Response to Submissions Report
Budawang School
SSD-8845345

On behalf of
NSW Department of Education
July 2021

SITE PLAN

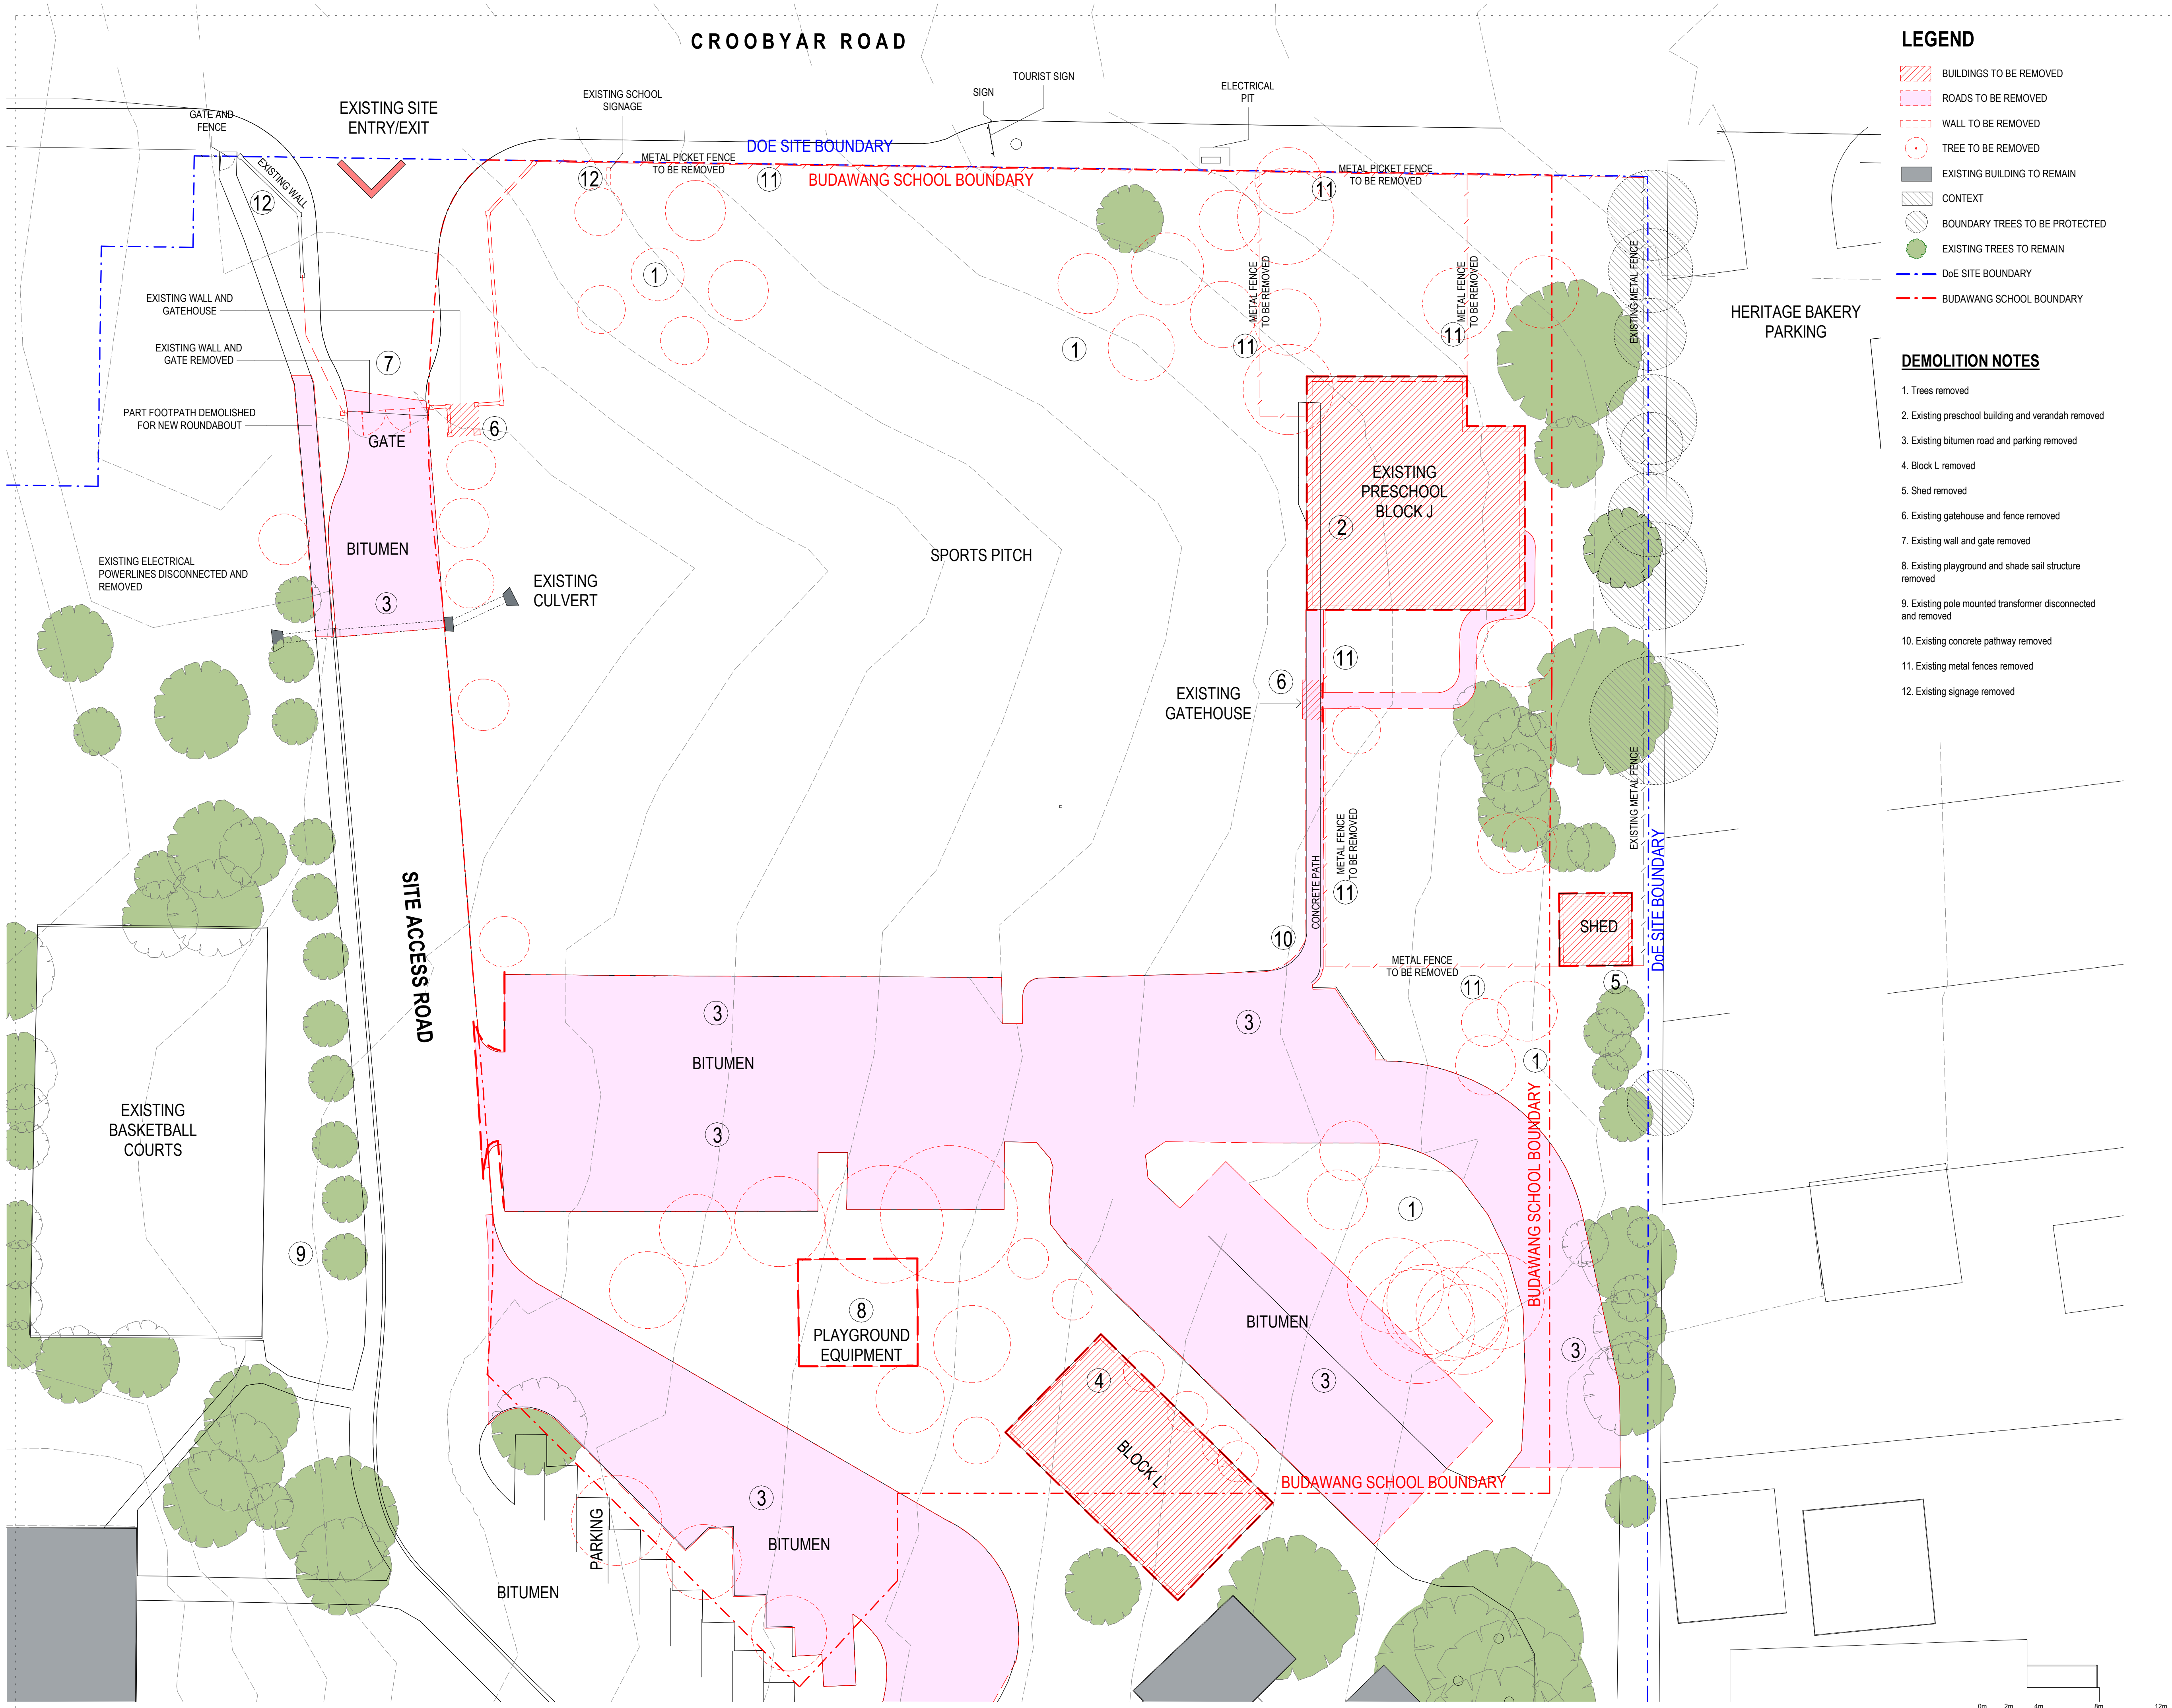
Summary of issue/comment	Response
<p>Location of entry gates</p> <p>The entry gates on the main road should be located to the south of the roundabout to enable the remainder of the former school site to be secured while public access is provided to the car park for after hours use of the hydrotherapy building.</p>	<p>Council's suggestion has been incorporated in the updated plans. The entry gates on the main road have been moved to the south of the roundabout. As Council notes, this allows for the remainder of the site to be secured while public access is provided to the car park for after-hours use of the hydrotherapy building.</p>
<p>Section 68 application</p> <p>No Section 68 application has been lodged for consideration.</p>	<p>A Section 68 application will lodged for any work covered under Section 68 of the Local Government Act 1993 as required.</p>
<p>National Construction Code (NCC)</p> <p>No National Construction Code (NCC) assessment has been completed. The submitted NCC indicates compliance is achievable, and the proposal may be subject to performance-based solutions.</p>	<p>This is correct. It is expected that compliance with the NCC will be required as a condition of consent.</p>

<p>Entry gate moved from north of proposed roundabout to south of roundabout. Fencing has been added to the west of the existing pathway due to relocation of the site gate.</p> <p>The updated entry is shown in the plan extract at Figure 3 below the table.</p>	<p>This change has been made in accordance with a recommendation by Council in its submission. The new gate location allows for the remainder of the site to be secured while public access is provided to the car park for after-hours use of the hydrotherapy building.</p>
<p>Hydrant booster has been added along the Croobyar Road frontage. The location is shown in the plan extract at Figure 4 below the table.</p>	<p>The booster has been added in accordance with advice from the hydraulic engineer. The booster will not result in any significant visual impacts and will not require tree removal.</p>
<p>Two additional trees added along Croobyar Road near substation.</p>	<p>This change was made in response to Council's comment regarding the apparent incomplete row of trees along Croobyar Road. This row of trees was previously "incomplete" due to concerns regarding clearance distances around the substation. The clearances have since been verified, and the two additional trees are outside of the clearance zone.</p>
